# City of Albuquerque Stormwater Construction Site Inspection Report

ESC File No.	B18E028	Project Name:	Burger King		
NPDES Id. No.	NMR100463	Location:	2110 Carlisle Blvd. NE		
2/28/2022	Owner	Contractor			
Operator	Auto Nation USA	Rycon Construction Inc			
Contact name & title	Fred Moss	Michael Burns			
e-mail	<a href="mailto:mossf@autonation.com">mossf@autonation.com</a>	<a href="mailto:mburns@ryconinc.com">mburns@ryconinc.com</a>			
Contact Phone #	954-769-2303	263-6965			
COA Inspector	Doug Hughes	Start/End Time:	4pm		
Construction Phase:	Excavation/grading				
Type of Inspection:	<input checked="" type="checkbox"/> Regular	<input type="checkbox"/> Storm Event	<input type="checkbox"/> Past Storm Event >0.25"	<input type="checkbox"/> 311/Complaint	<input type="checkbox"/> Follow Up
Weather at time of inspection?		clear		Temperature: ~	60
Estimated date of last storm 0.25" or greater		2/2/2022

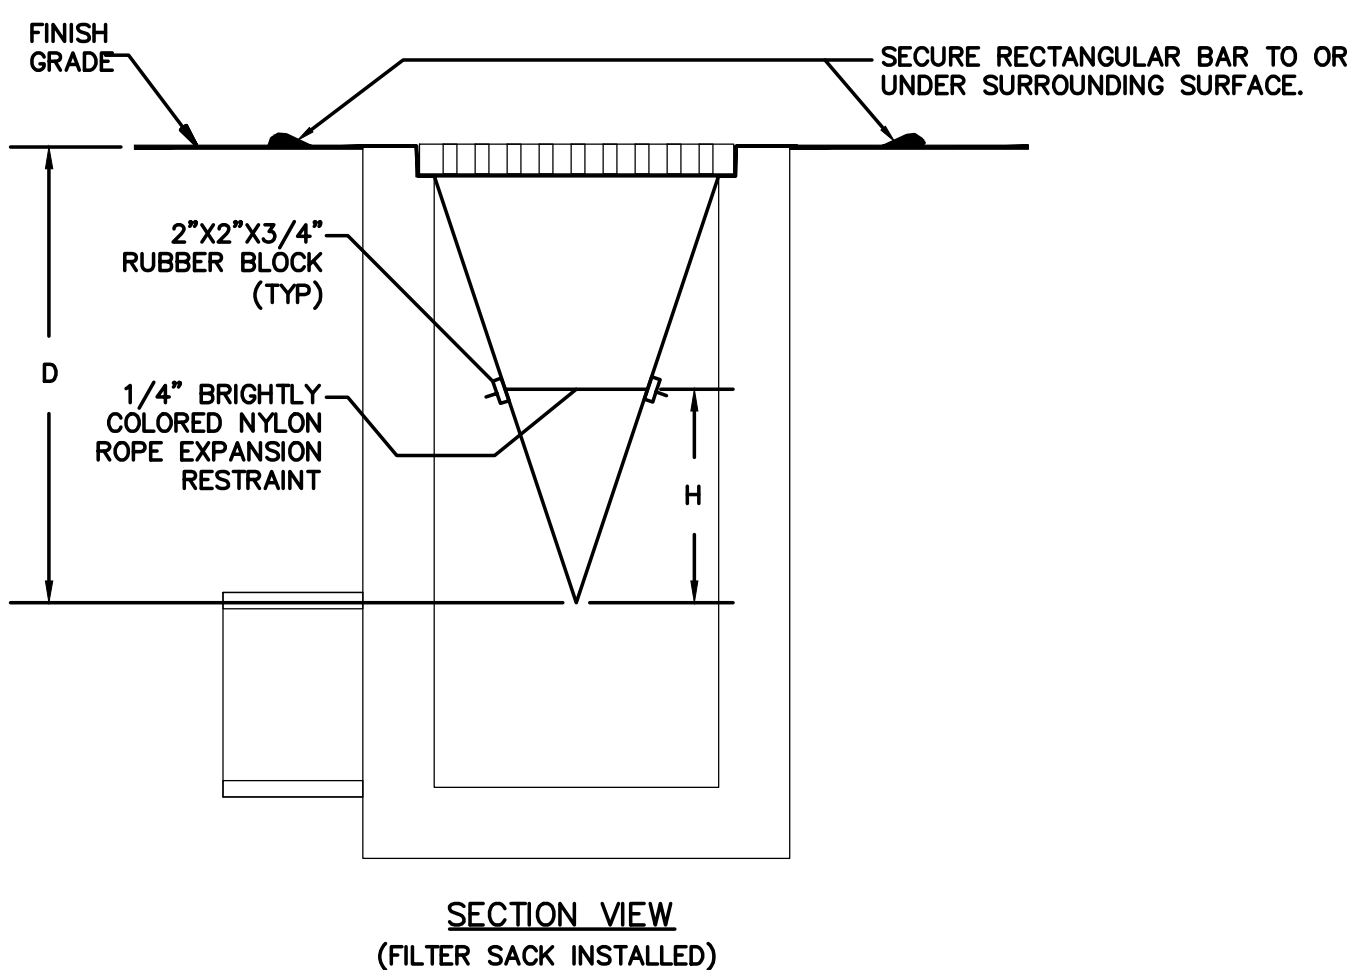
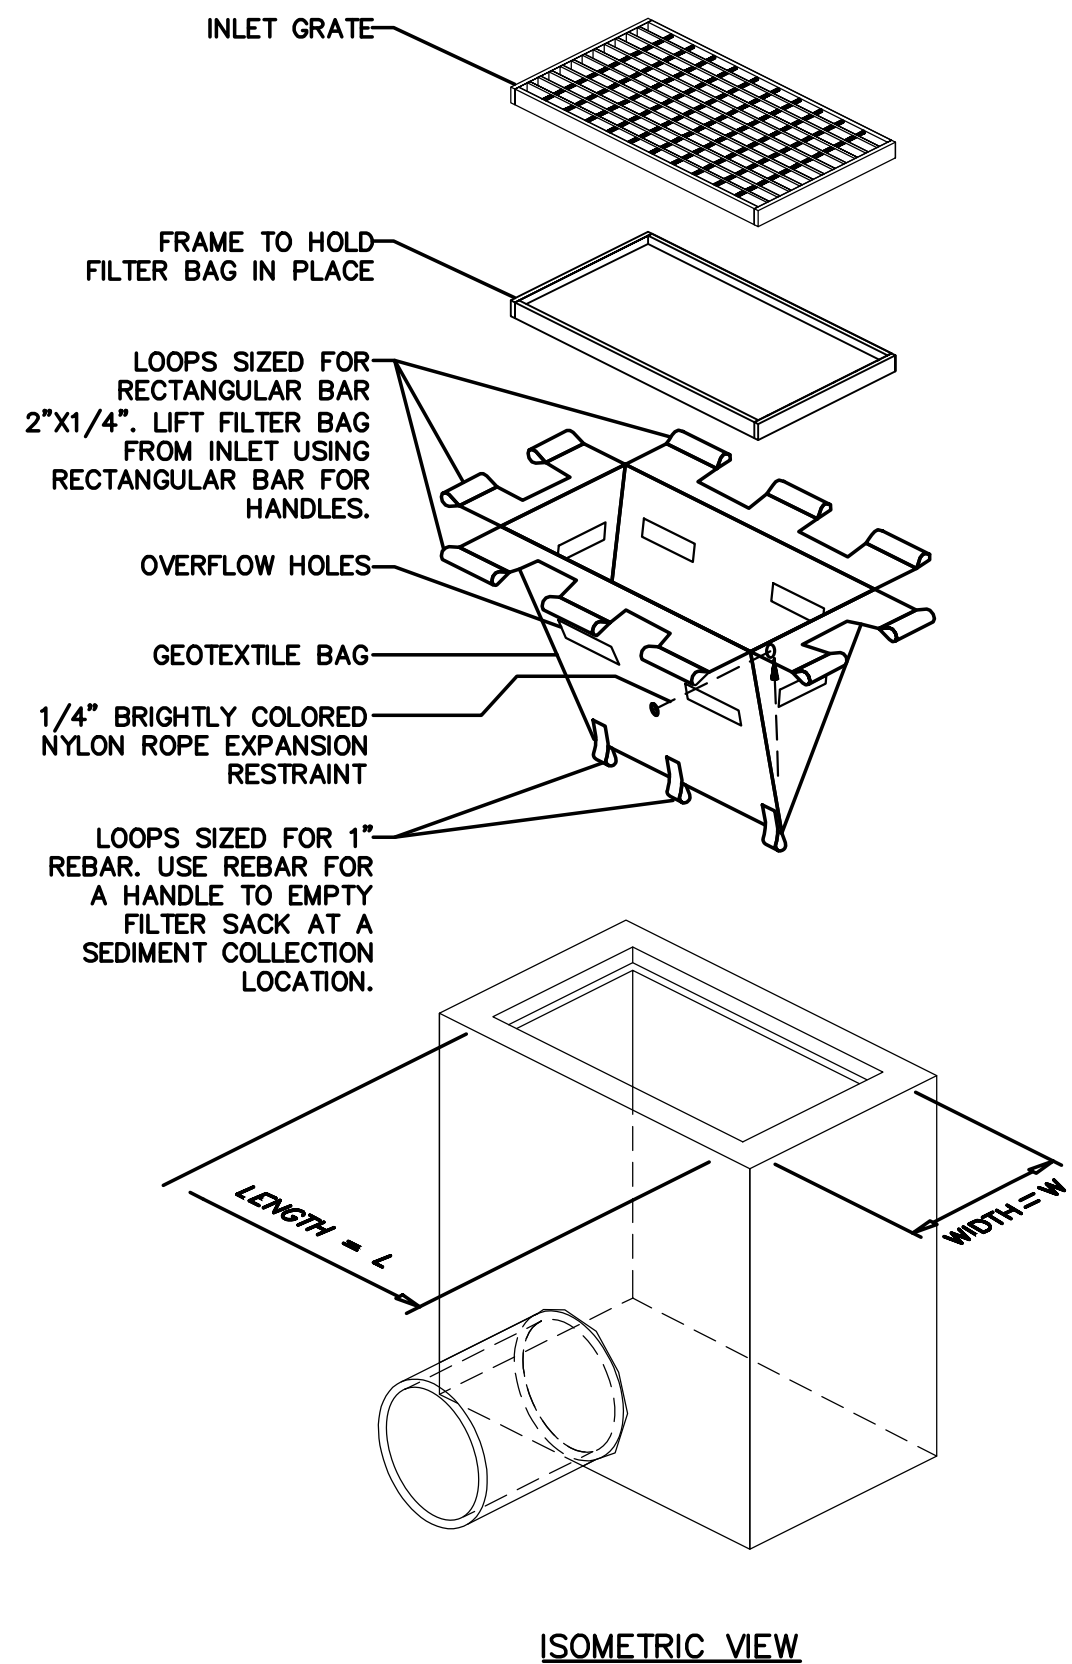
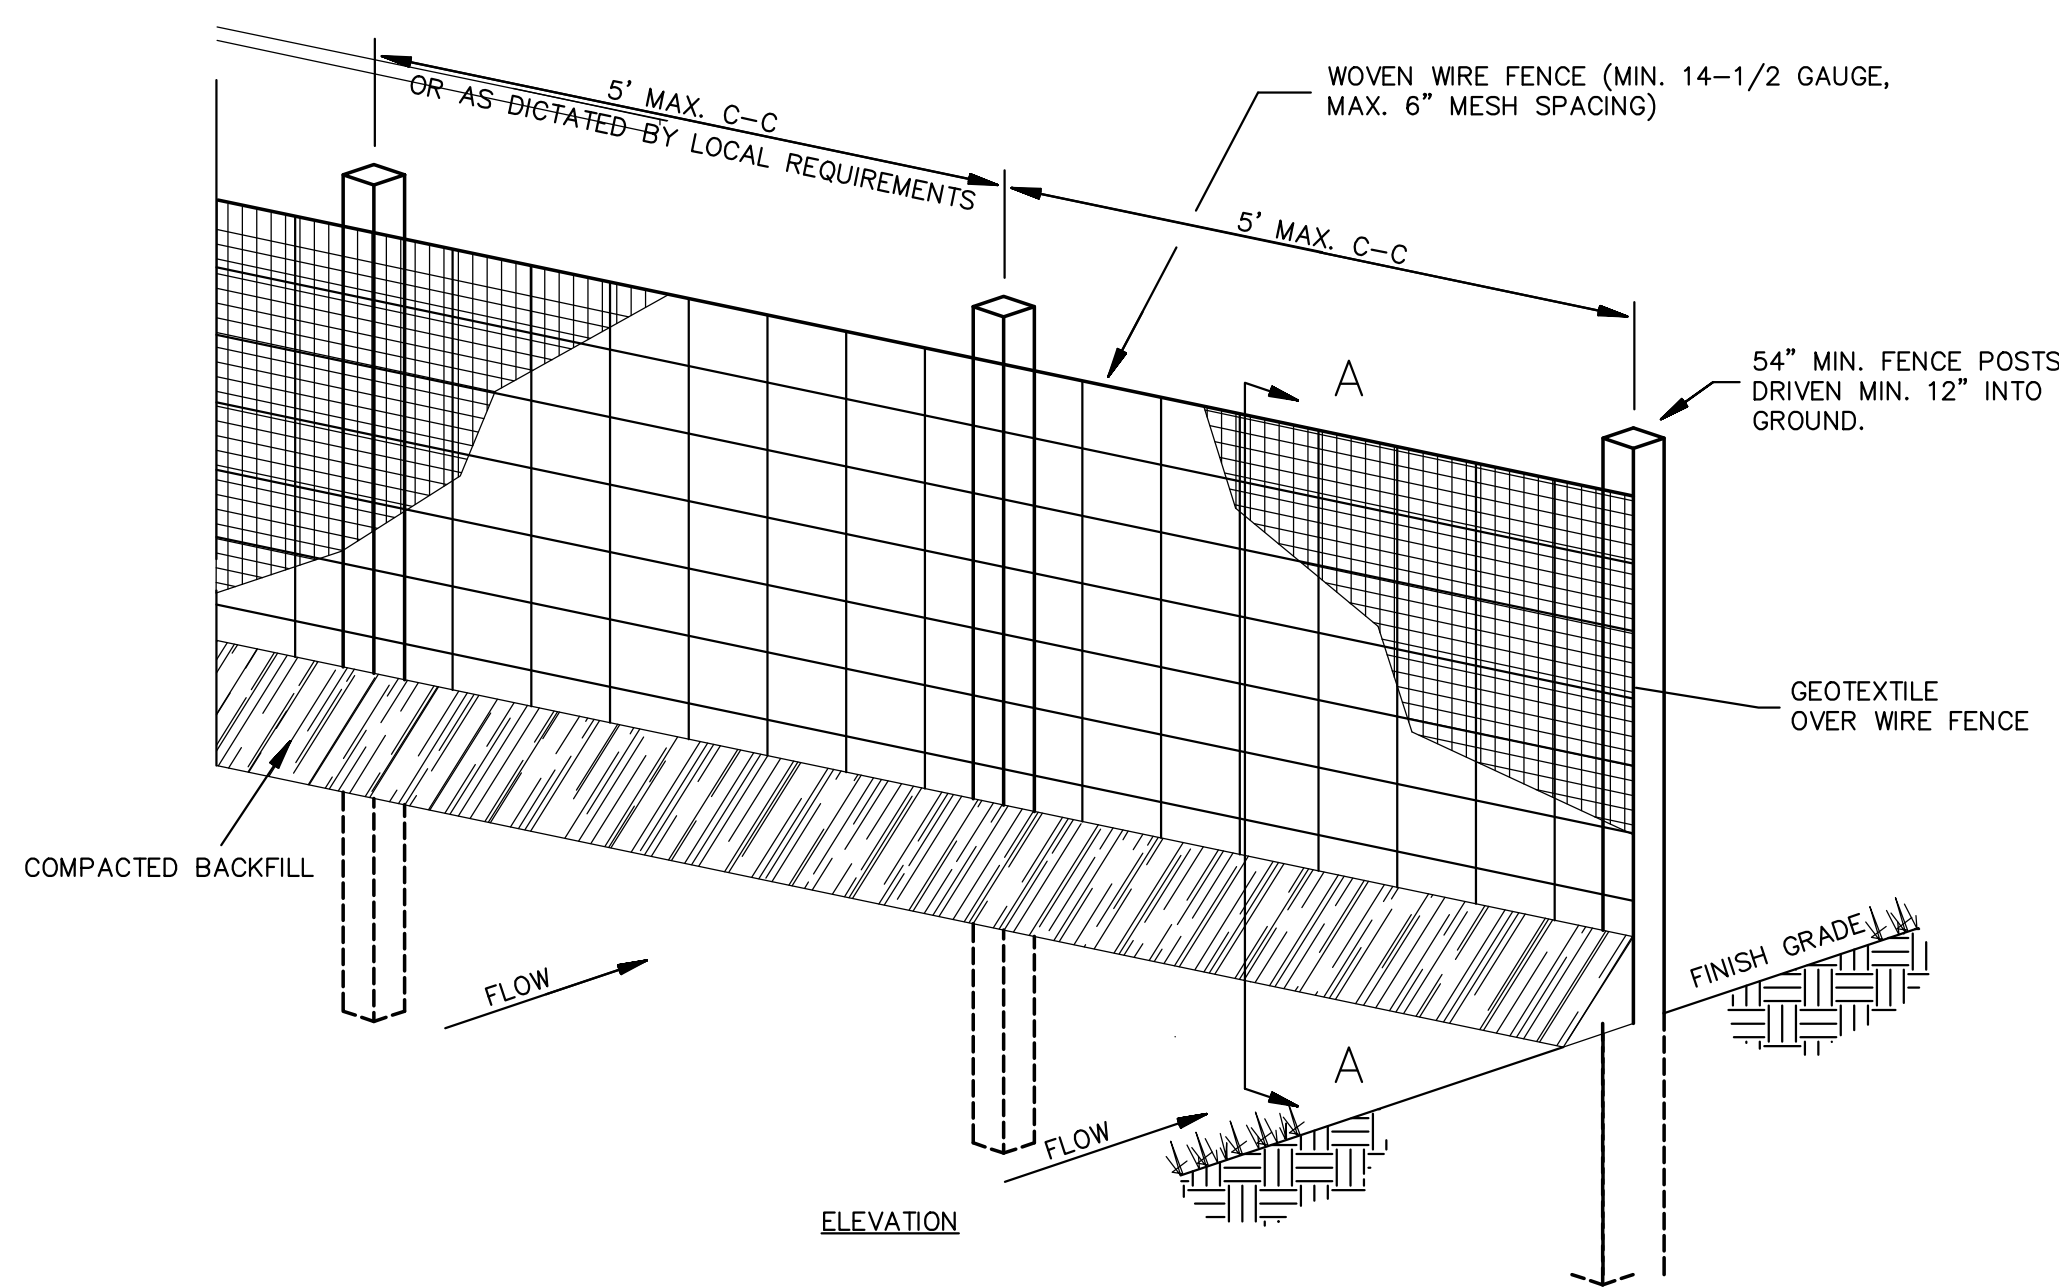
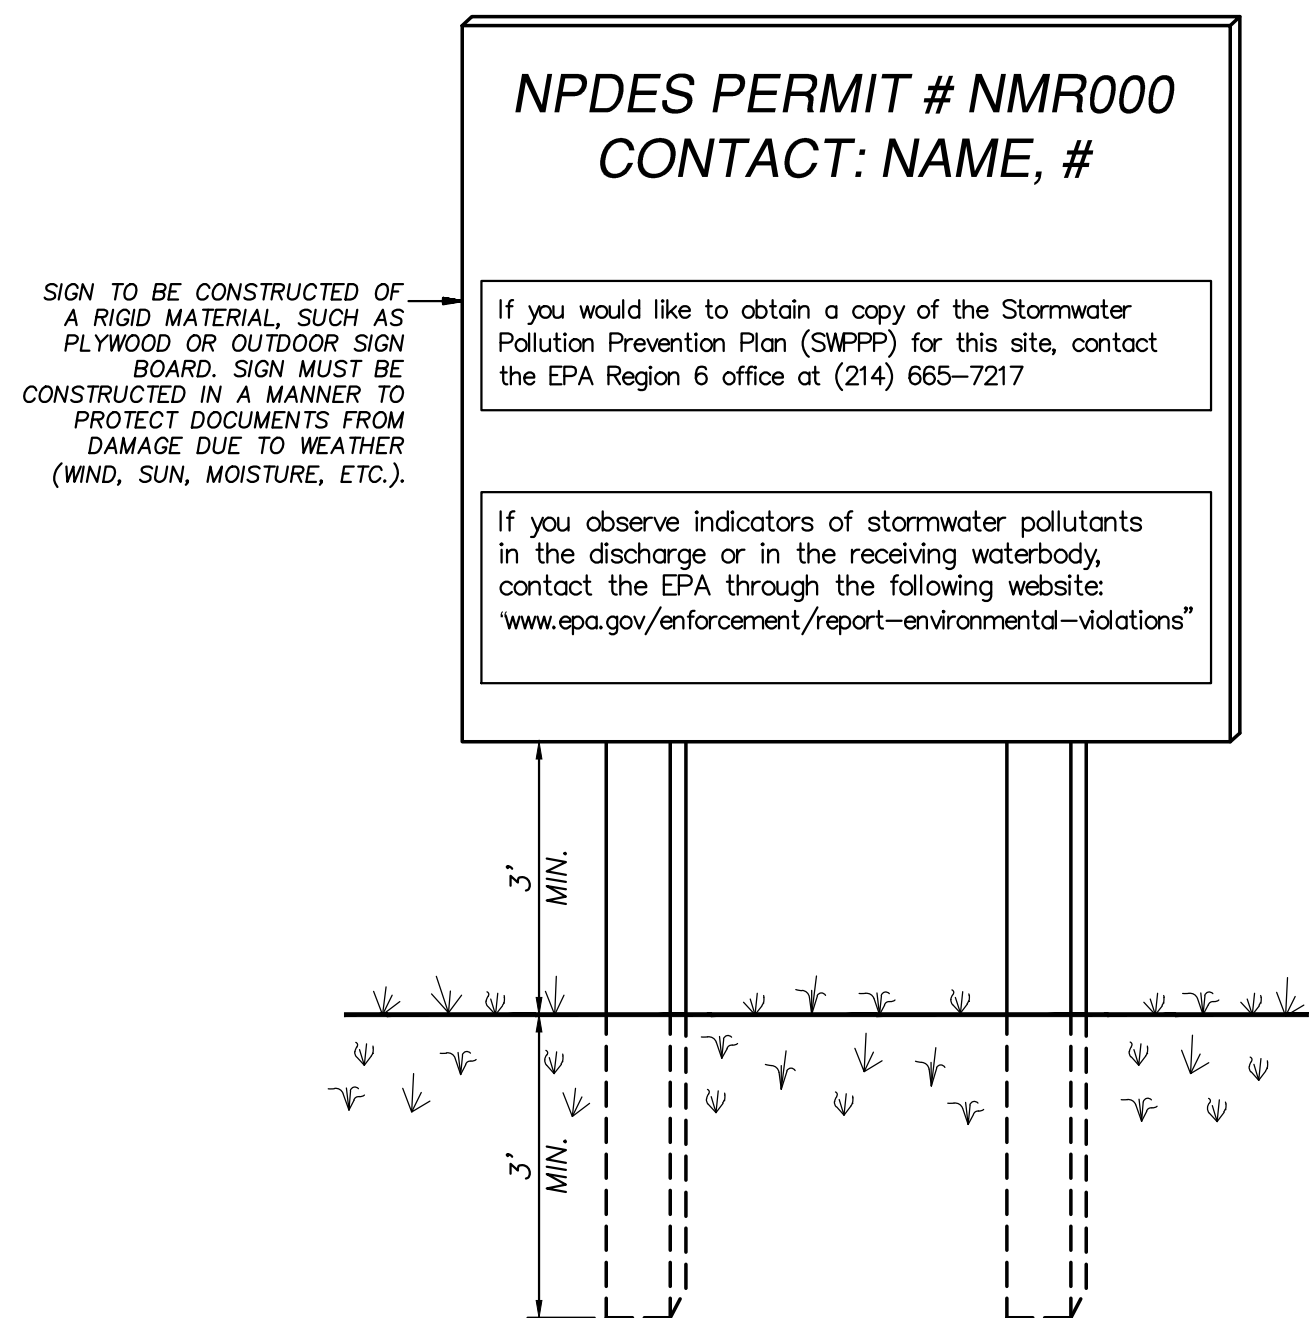
Notes:	
Foundation footings excavated and steel in the trench, but no washout container on site.	
The area of land disturbing activities has been increased to include the two lots adjacent to San Pedro, so the SWPPP map and NOI need to be revised, to update the SWPPP.
